**TOWN AND COUNTRY PLANNING ACT 1990 (AS AMENDED)  
THE TOWN AND COUNTRY PLANNING (ENVIRONMENTAL IMPACT ASSESSMENT)  
(ENGLAND AND WALES) REGULATIONS 1999  
Planning Application N6/2010/2055/MA - Former Shredded Wheat Factory Complex  
and Land Adjoining at Broadwater Road West, Welwyn Garden City**

# REVISED BROADWATER ROAD WEST ENVIRONMENTAL STATEMENT, FEB 2011

## REVIEW OF COMPLIANCE OF FEB 2011 ES WITH REGULATION 19 NOTICE

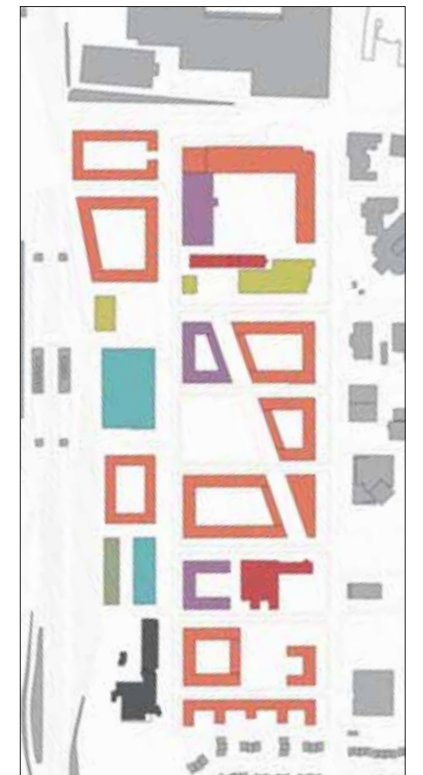
- **At 2.1.15 and 2.5.4 of Part B the text states that supermarket car park entrance is under building K, but it is under building F.**
    - **At 2.1.17 of Part B comment is made on the heights of the development at the southern end of the site and that they comply with the SPD guidance which suggests lower rise buildings. This does not seem to tally with parameter plan 568\_PP\_07\_011 which indicates buildings up to 16.3m high on Plot Q and up to 13.3m on Plot P.**

Car Parking and Basement Access

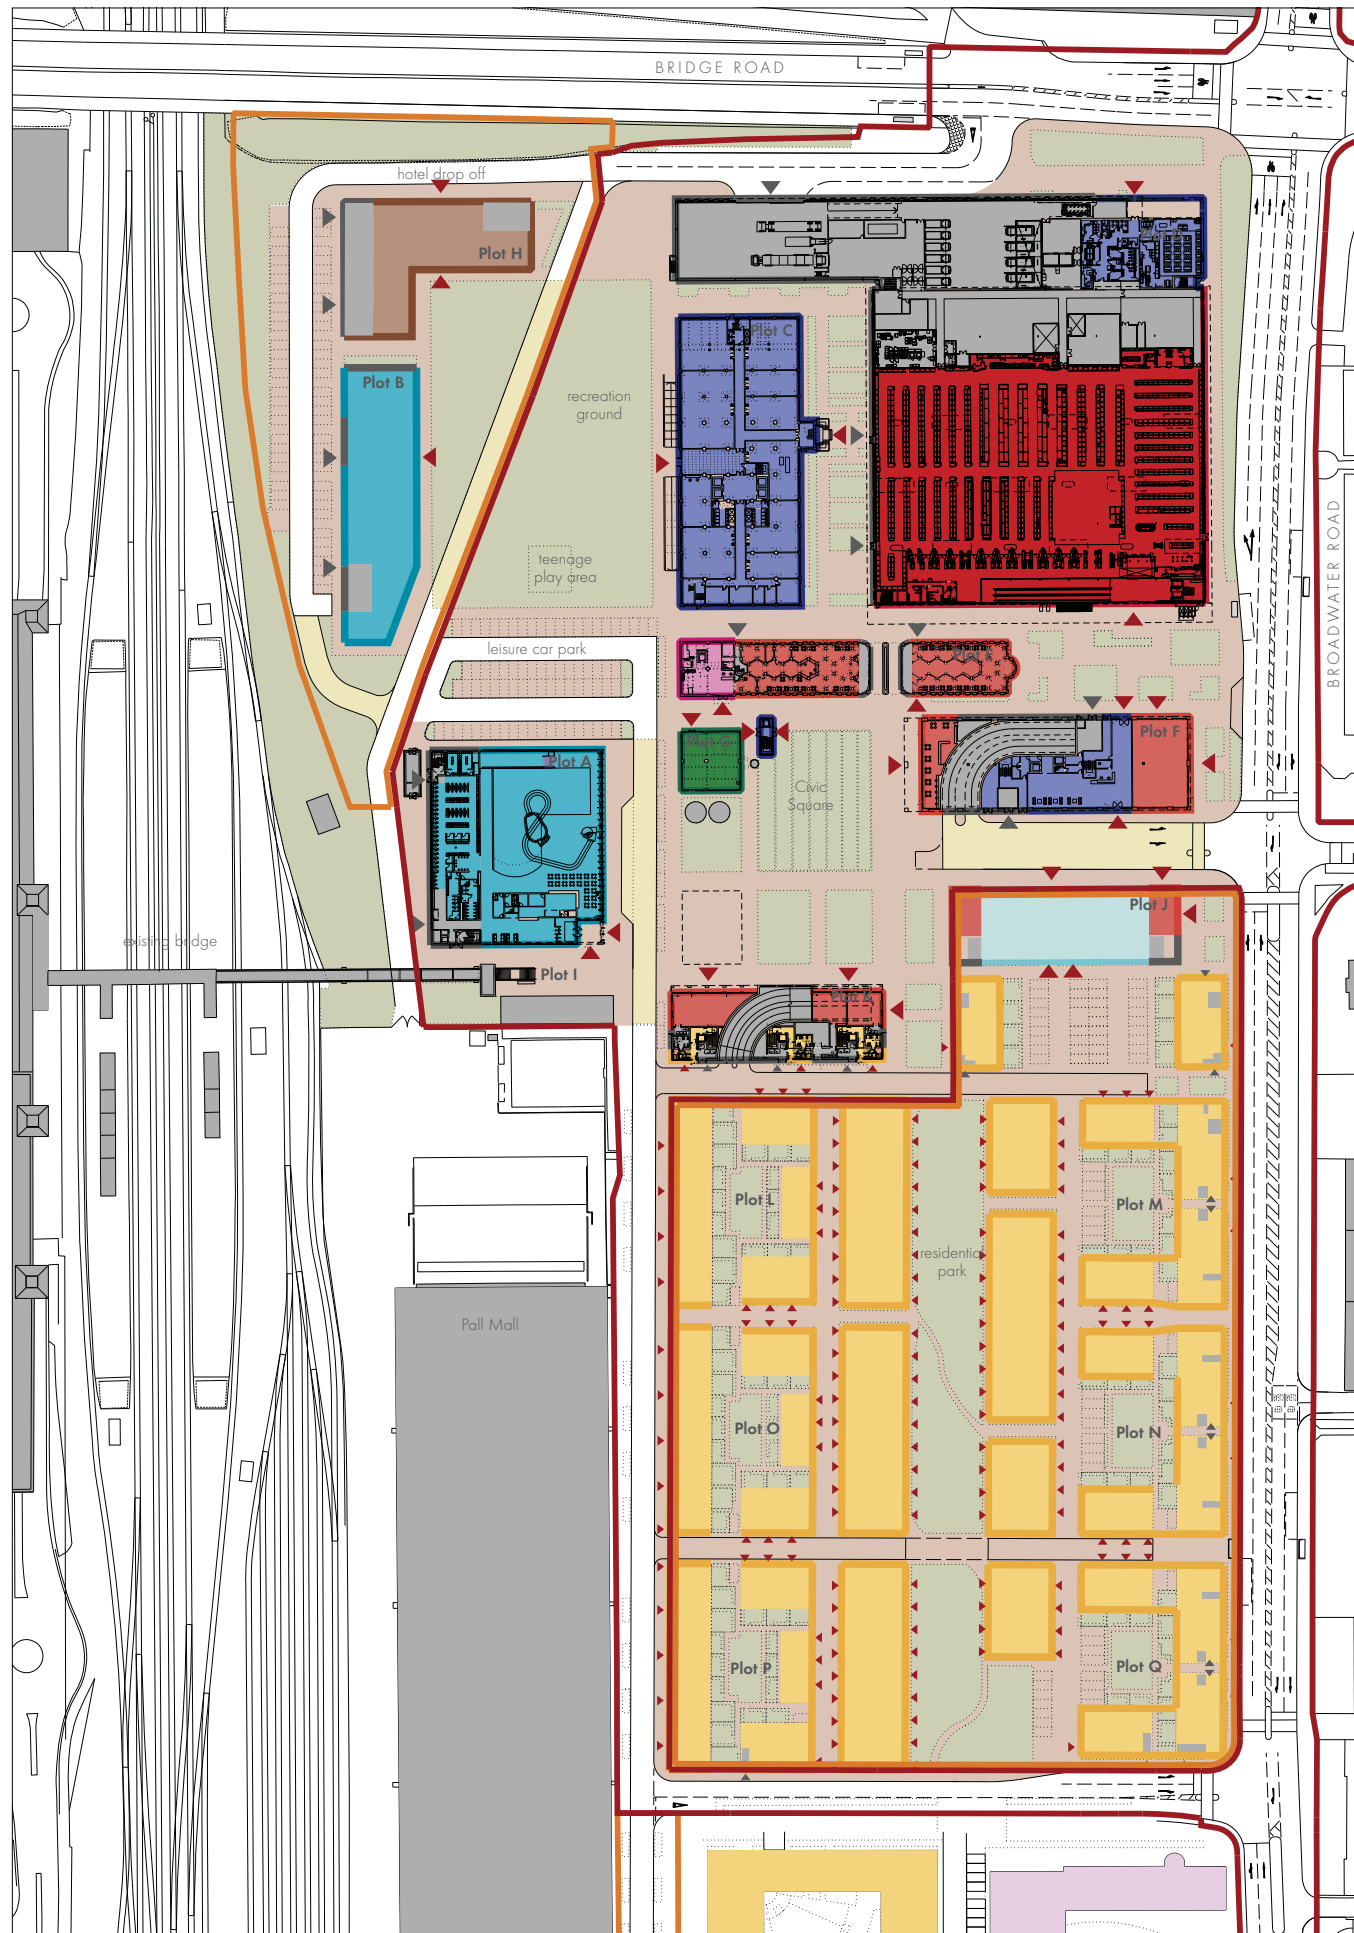
- At 2.5.4 of Part B the number of car spaces in the text do not tally with those shown in the table following, furthermore, the table does not tally with fig 568\_07\_119.
